Recommendation Report for Planning Permission for Works or Extension to a Dwelling

REF NO: FG/19/26/HH

LOCATION: 49 Rife Way
Ferring
BN12 5JY

PROPOSAL: Proposed two storey extension.

Proposed Side Elevation (West). Scale 1:100

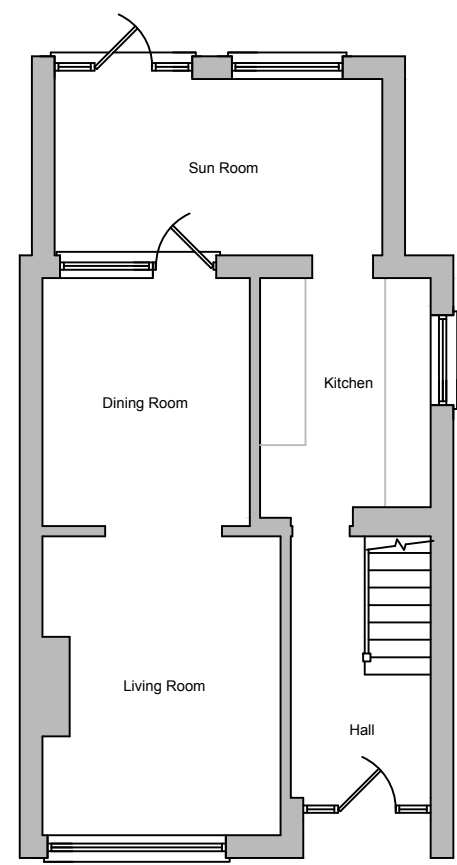
The two storey side extension would have a width of 1.8m. Consequently, the western flank elevation would be set in from the western side boundary by 0.85m, contrary to Arun Design Guide (ADG) advice, which suggests a minimum of 1m at ground floor level and 2m at first floor level. The side extension would also not satisfy the 70-degree rule for side extensions, which aims to avoid any undesirable terracing effects.

Whilst it would be preferable for the two storey side extension to be set down from the ridge height of the existing dwelling, as well as from the front and rear, and it is noted that the extension would not be a subservient addition to the host dwelling, the extension does respond positively to the existing pitched roof and gable end, in keeping with established design in the locality.

The single storey element of the side extension, in the south eastern corner, would incorporate a mono-pitched roof, sloping upwards towards the centre of the host dwelling with the gable of the extension abutting the existing flat roof. Predominantly, other rear extensions in the locality have incorporated flat roofs, however the mono-pitched roof would be an innovative and contemporary design choice, as per ADG guidance, and would not result in harm to design or visual amenity.

Fenestration is proposed at ground and first floor levels within the front, rear and western flank elevations of the extension. The proposed front fenestration would have an outlook over the application site frontage, and would not result in overlooking. The fenestration within the rear elevation would have views of the rear amenity space serving the host dwelling. Whilst some views of neighbouring gardens would be available from the first floor rear fenestration, these views would not be significantly different to those already available, and the proposed rear fenestration would not result in unacceptable overlooking. The proposed ground floor fenestration within the western flank elevation would serve a kitchen, and would be screened from the neighbour to the west by boundary treatment. The first floor window within the western flank would replace an existing window in a similar location, however, given that the proposed first floor side window would be closer to the western side boundary than the existing, it is reasonable to attach a condition to this planning permission to require this window to be obscurely glazed and non-openable below 1.7m above the internal floor level, to avoid a significant increase in actual and perceived overlooking of the neighbour to the west.

- 3 The first floor window within the western flank elevation of the building shall at all times be glazed with obscured glass to a level equivalent to Pilkington Level 3 or nearest equivalent standard and non-openable below 1.7m above finished floor level. This arrangement shall be permanently retained thereafter.

Proposed Ground Floor Plan, Scale 1:50

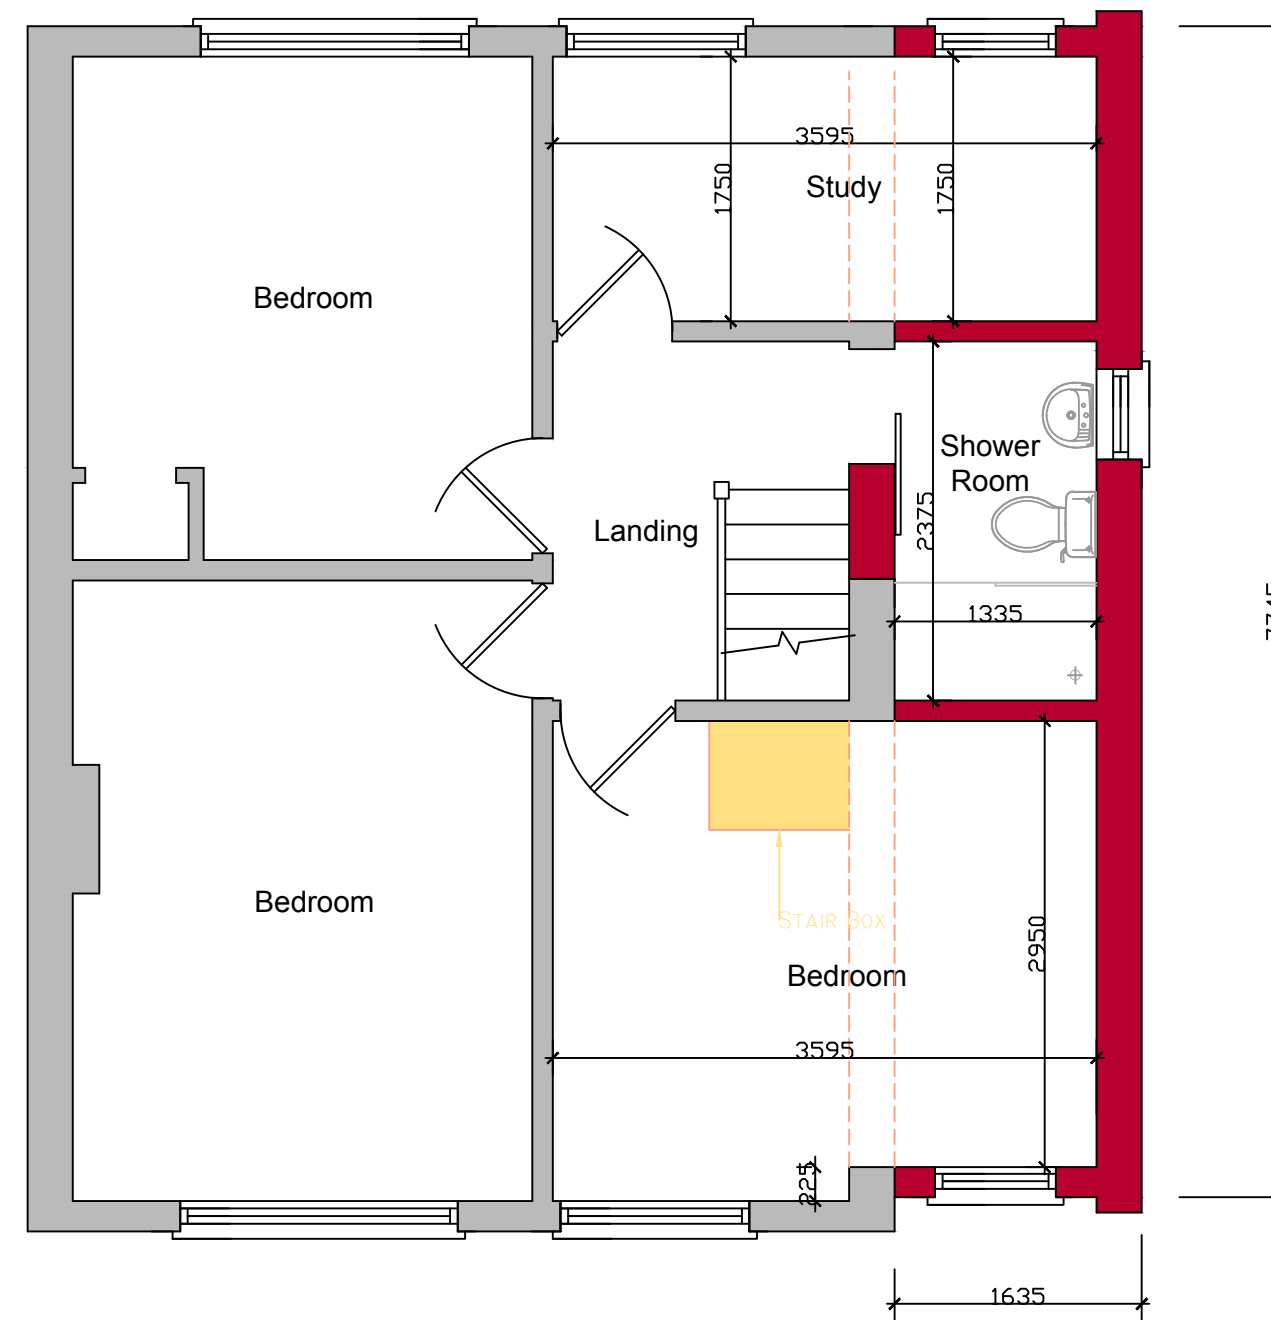
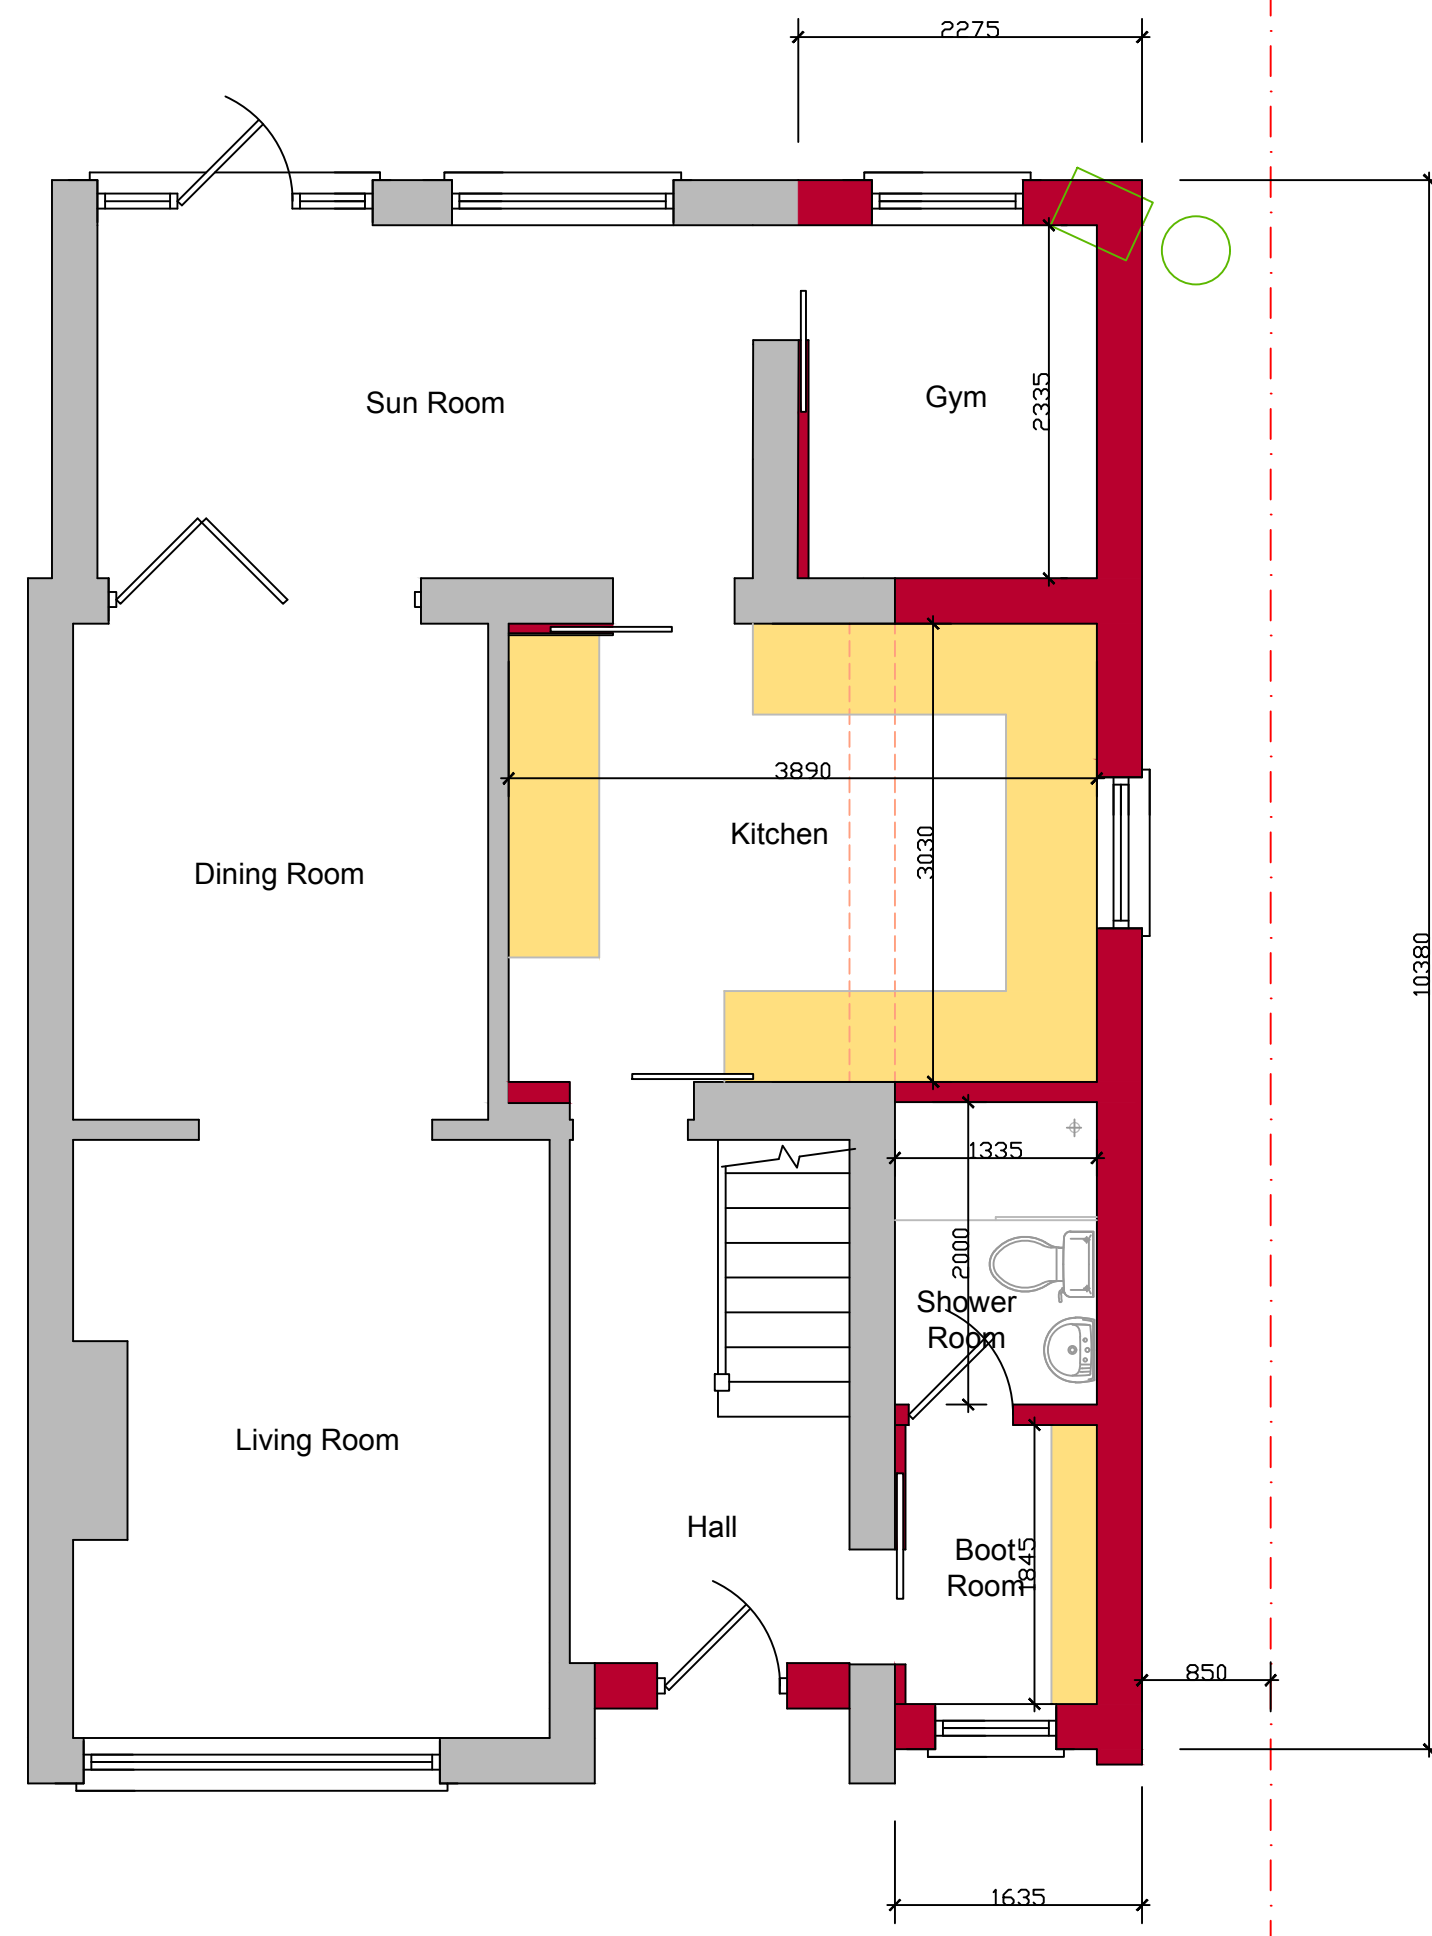
The proposed side extension would be set in from the site boundary by 0.85m. Whilst the proposed spacing would not be in accordance with the ADG advice, the western flank of the extension would be set in approximately 3.2m from the eastern flank elevation of 51 Rife Way. The mono-pitched roof on the single storey element of the extension would be angled away from the site boundary, extending only approximately 0.5m above the boundary fence at it closest point. Given this, the proposal would not result in undue harm by way of overbearing impacts.
